Notes to assist in negotiating the impasse on the submitted planning application. Prepared by a Conservation and Development Control Principal Officer with over 14 years experience within an East Lancashire Local Authority.

1. Appeal Decision: Inspector's Report

5. Reason for Refusal of 3/2021/0462

PLAN & ELEVATIONS OF GARDEN ROOM/OFFICE & STORE FOR
MR & MRS P HARGREAVES 1 PARK RD GIBURN

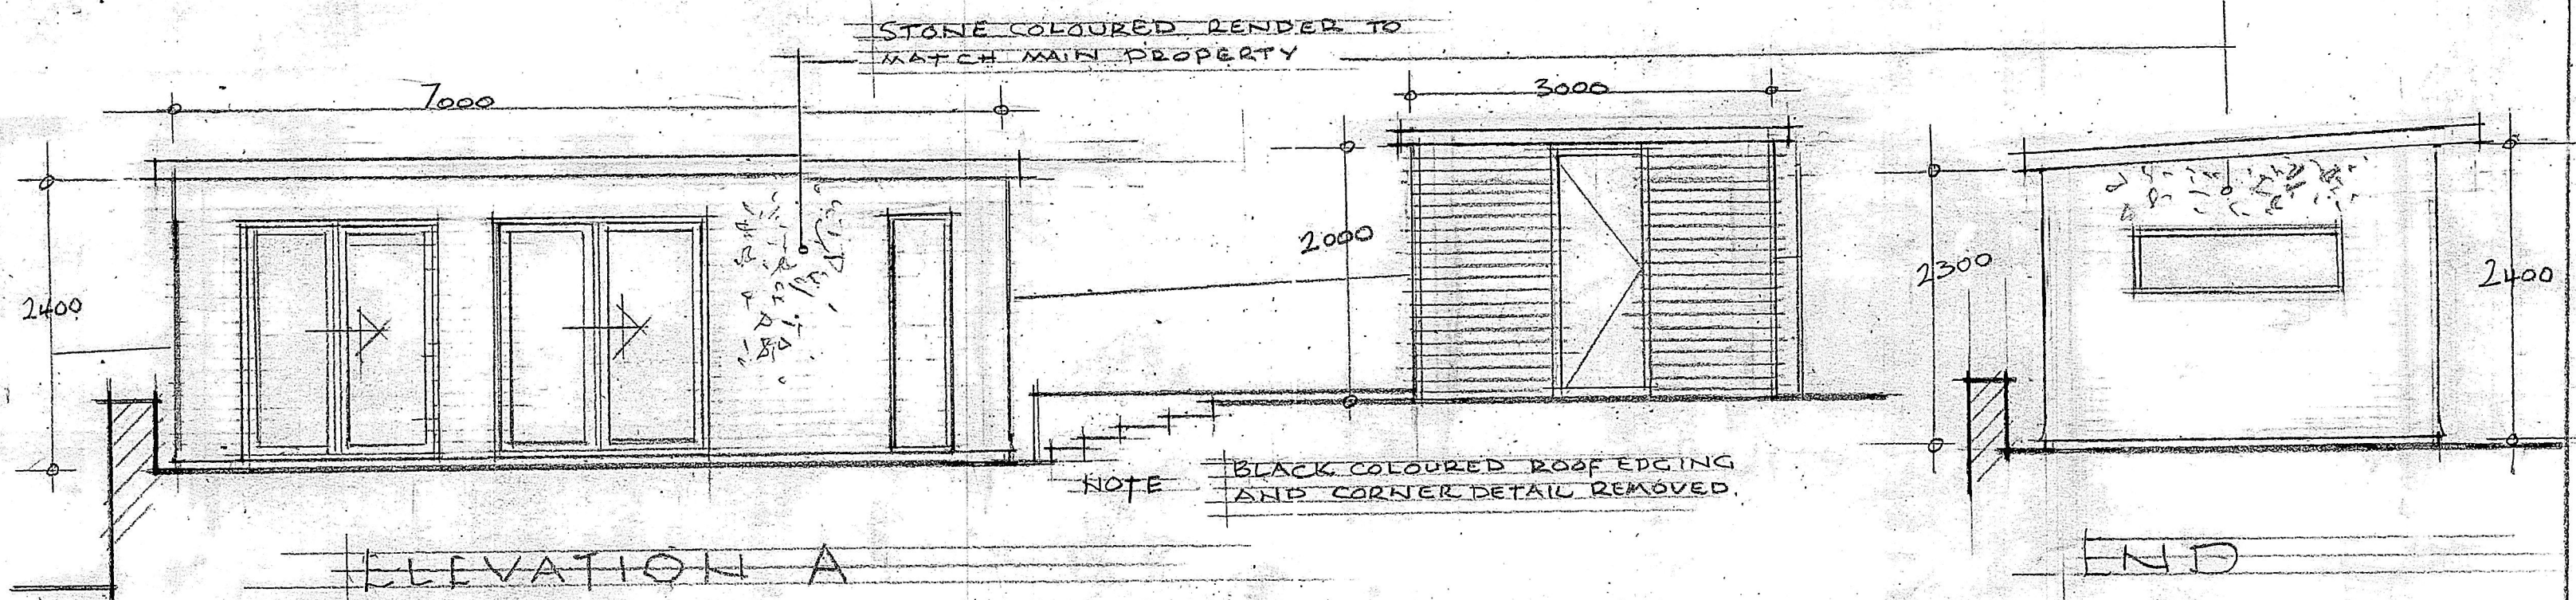
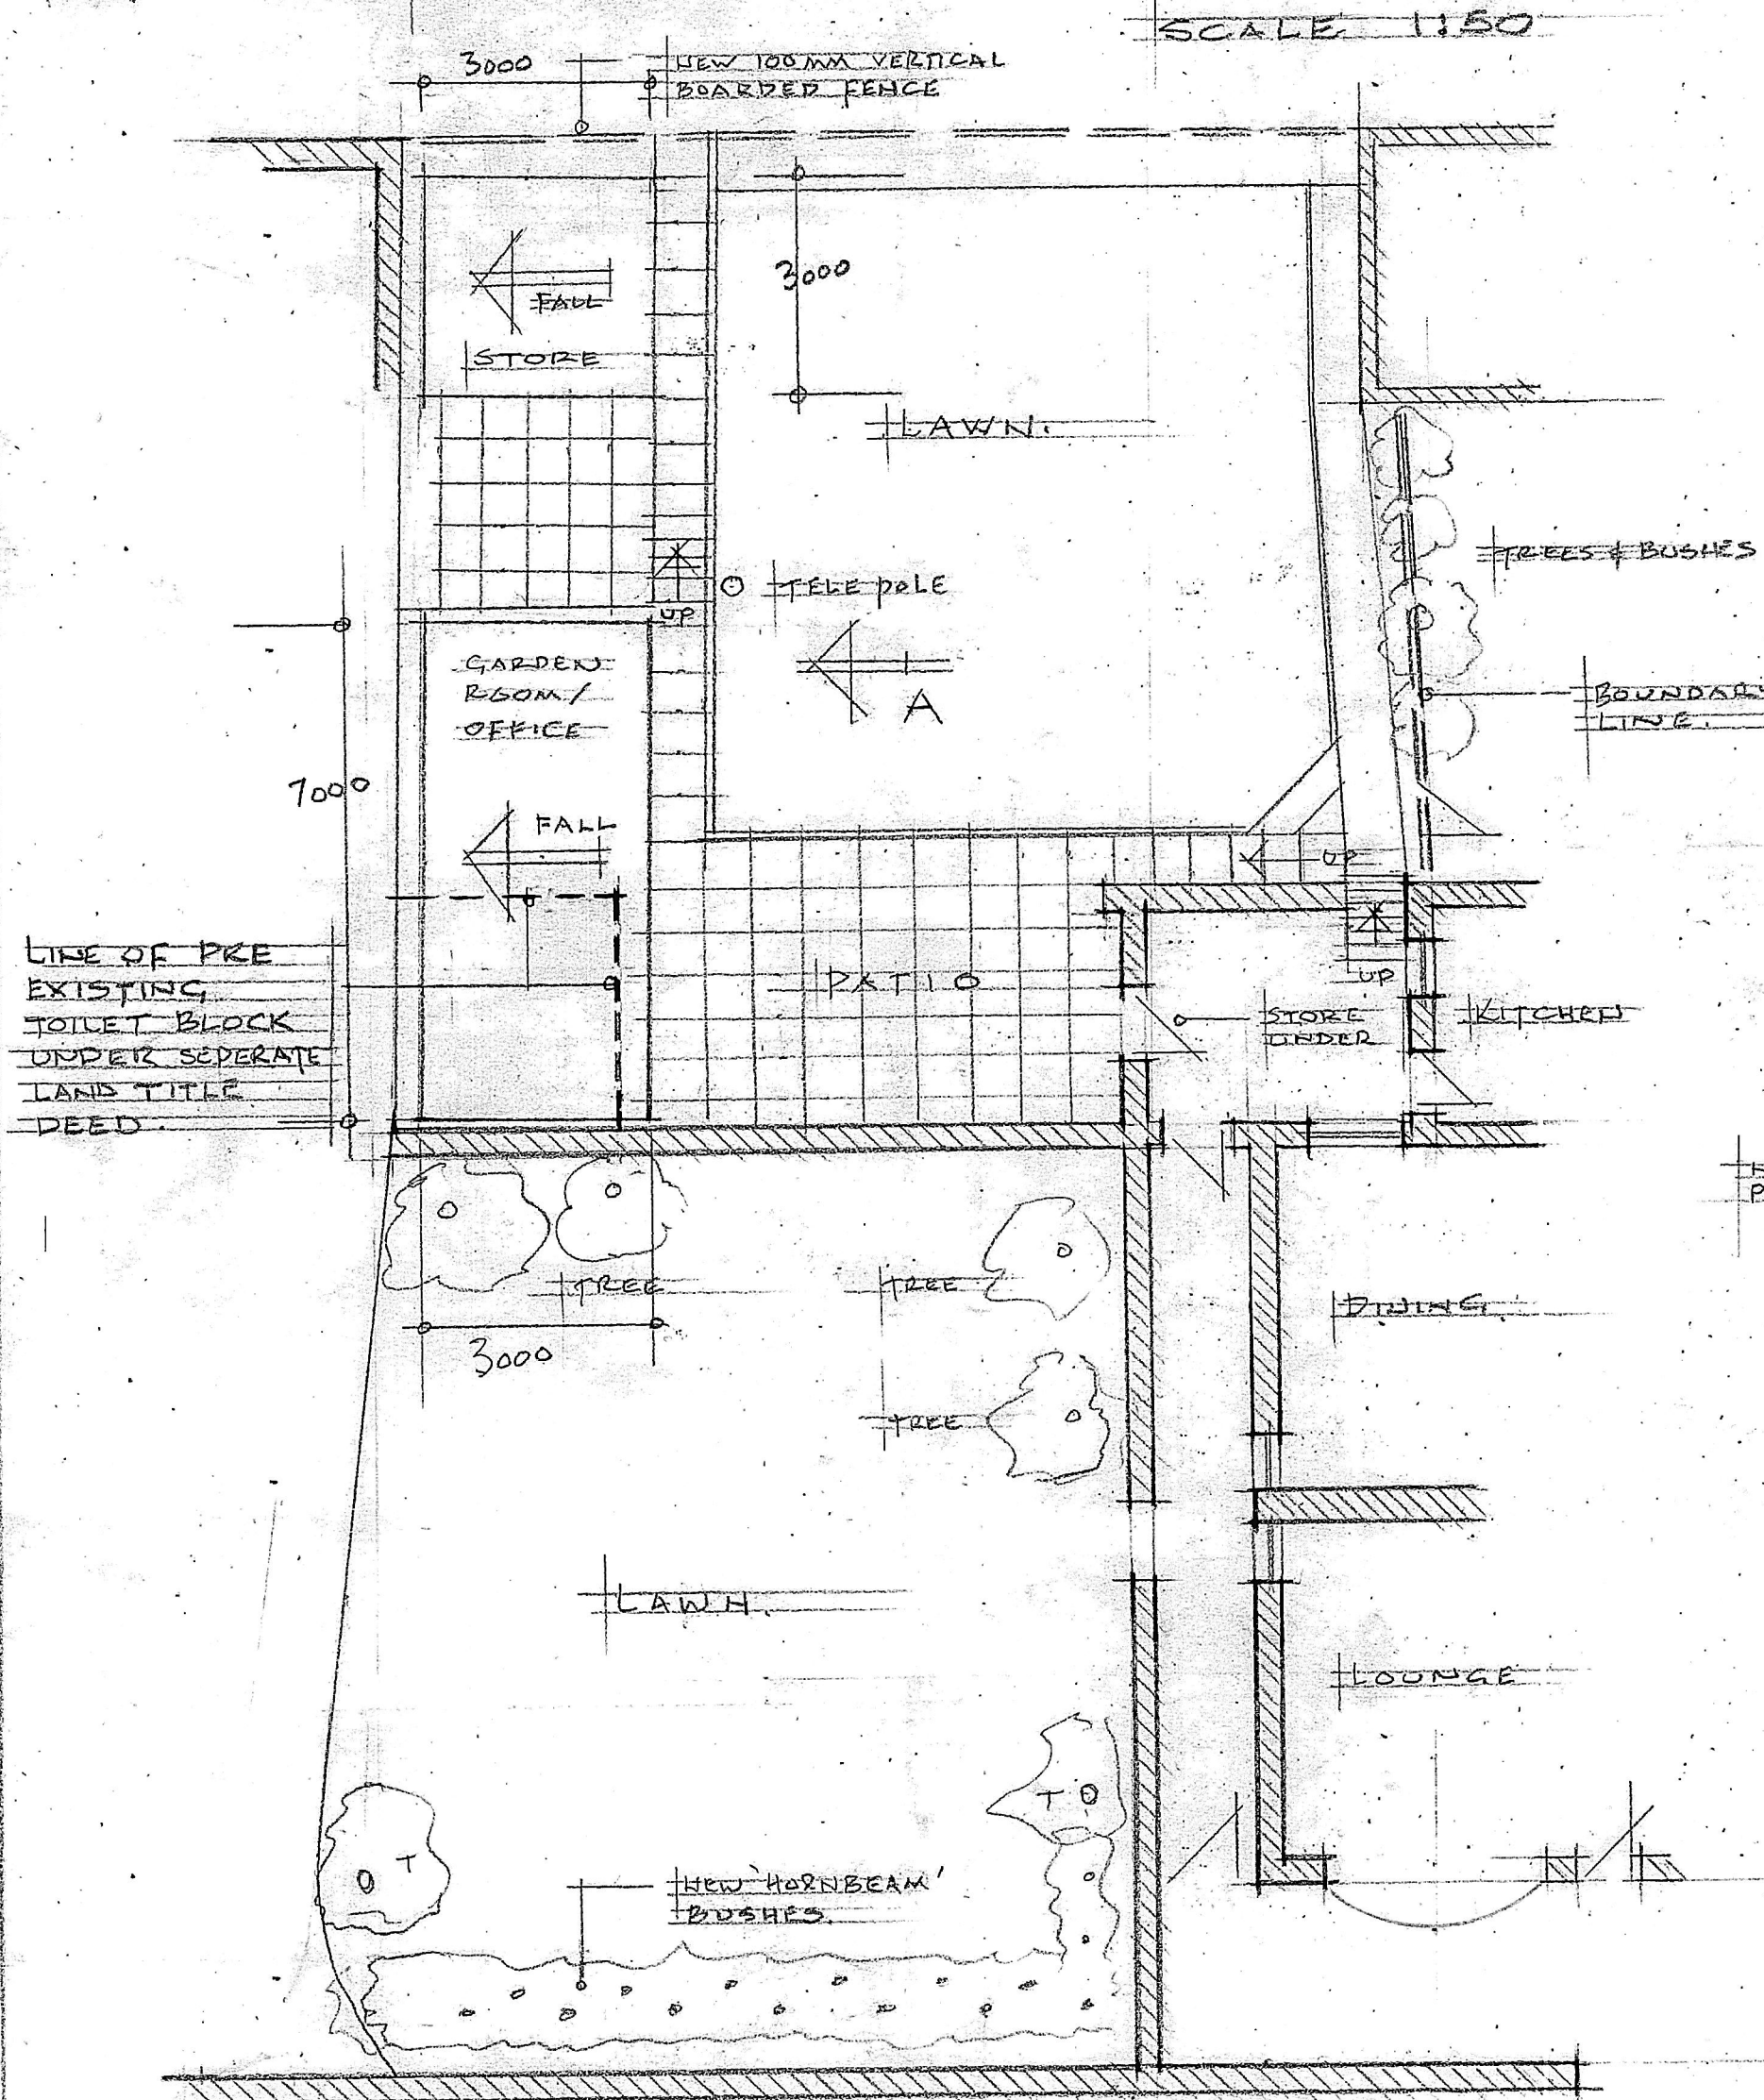
The Inspector considers the **roof detailing and corner detailing** to the shed and garden room to be cumbersome; drawing the eye and making the building appear unnecessarily dominant. Siting does not factor into the assessment and my professional view is that this is not a determining factor.

Having carefully considered the Inspectors Report and the facts of the case I am firmly of the opinion that the Inspector's view is that the principal harm is caused by the eaves and corner details rather than the main body of the structures or their siting. Accordingly, if the eaves and corner details could be appropriately remodelled to reduce visual bulk then a refusal would not be justified and could leave the Council open to costs at appeal. However for the avoidance of doubt, and in the interests of achieving high quality design, I would draw your attention to my recommendations of further revisions that would enhance the design and detailing and lessen the visual impact of the garden structures.

- **Amend proposed elevations to remove render.** Ancillary garden structures are typically timber. The existing timber cladding ensures that the building has a subservient appearance within the garden. The introduction of render, as proposed, would increase its visual dominance and permanence, and the stark flat elevations would lack the warmth of surrounding natural materials.

- **Introduction of sedum roofs.** Consideration has been given to adding a pitched roof however this would add unacceptably to the height and mass of the building thus increasing its visual impact. The roof form should be maintained as mono-pitch in order to ensure the building is suitably low profile. However it is considered that, in combination with accelerating the weathering of the timber cladding, the **introduction of sedum roofs** would better assimilate the structures into their garden surroundings whilst enhancing biodiversity.

- In addition to the removal of the black aluminium trim to eaves and corners as proposed, **consideration could be given to planting a moulded timber cornice to the eaves** to create depth and shadowing further reducing the visual bulk. Consideration could also be

given to reducing the degree of overhang or (if feasible) removing to create a much slimmer profile.

- **Maintain timber cladding to all elevations and accelerate weathering** through the application of a product such as SiOO:X Wood Protection. Once weathered the external elevations would fade to a shade of silver-grey which would blend more comfortably with the garden setting.
